Re: Lorraine Ct. Warehouse Grading and Drainage Plan

**Re: Drainage Plan & Grading Plan Submittal for Building Permit Approval and SO-19,
Lorraine Court Warehouse, Engineer's stamp dated 01-22-01 (D17/D067F)**

GRADING PLAN & DRAINAGE PLAN

GRADING PLAN

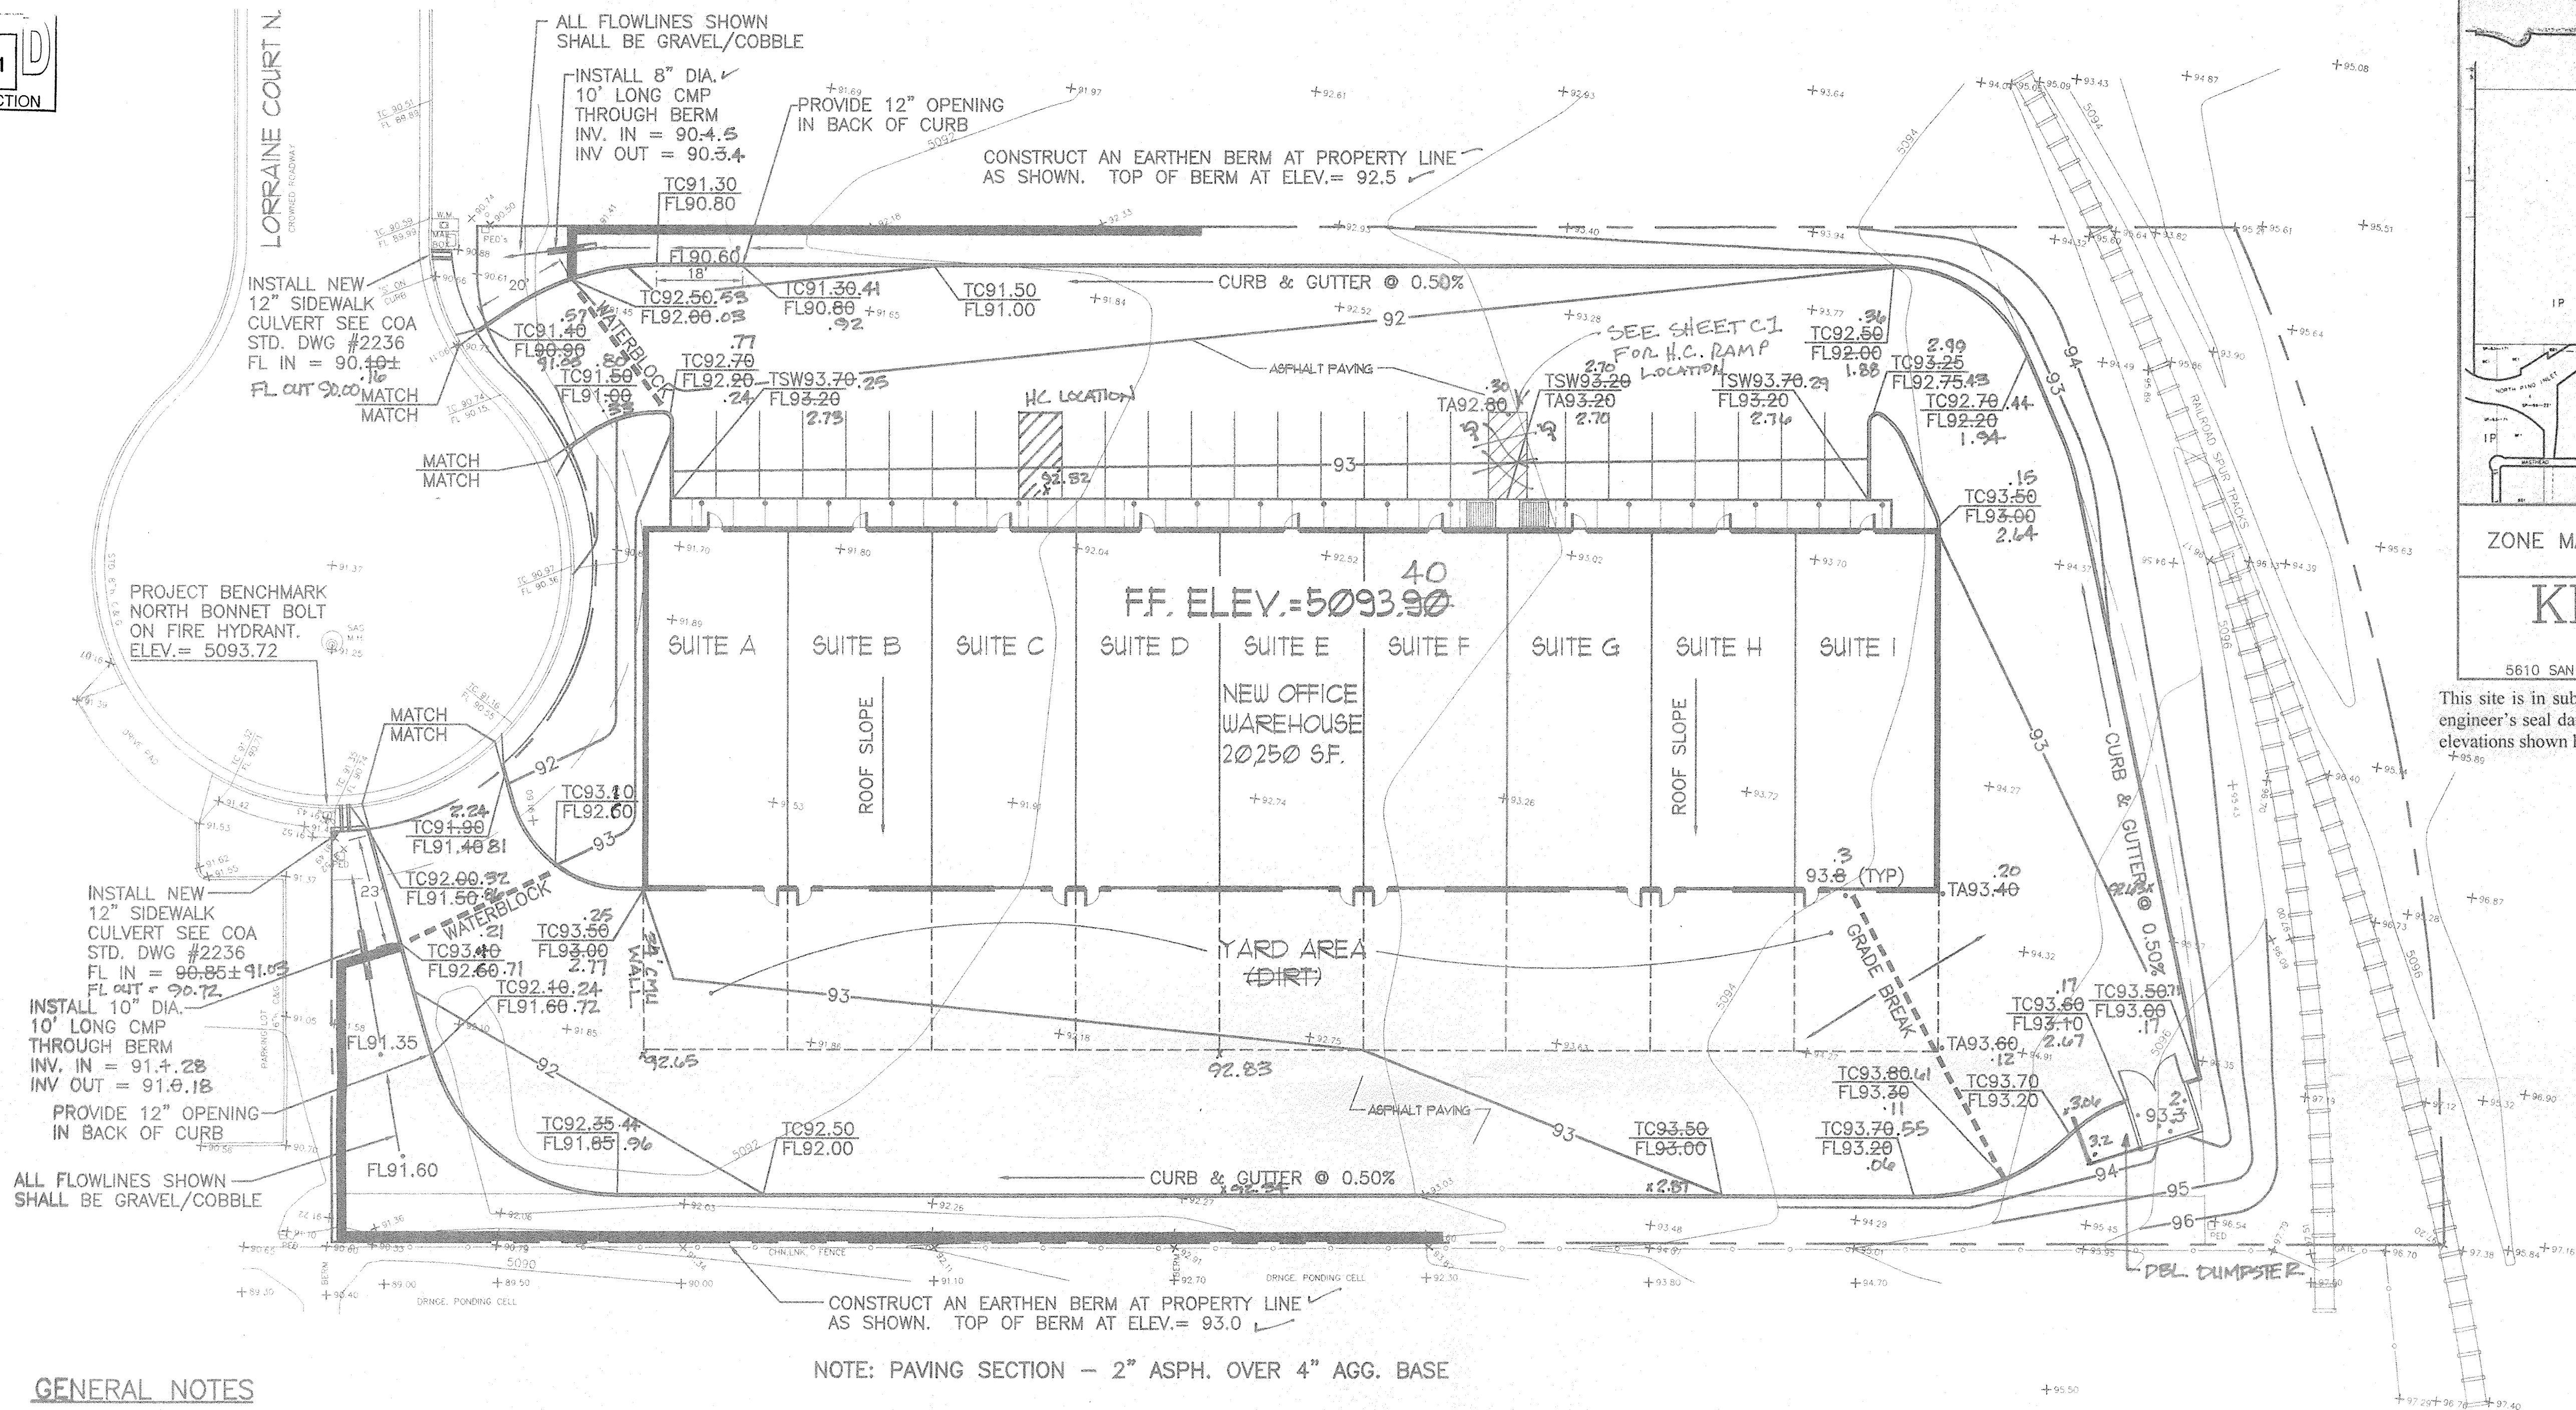
$$\text{Required storage} = \overset{8186}{\cancel{6,896}} - \overset{4340}{3,846} = 3,050 \text{ cf}$$

need 1040 more cu. ft.

Raise waterblock to 92.60 from 92.50
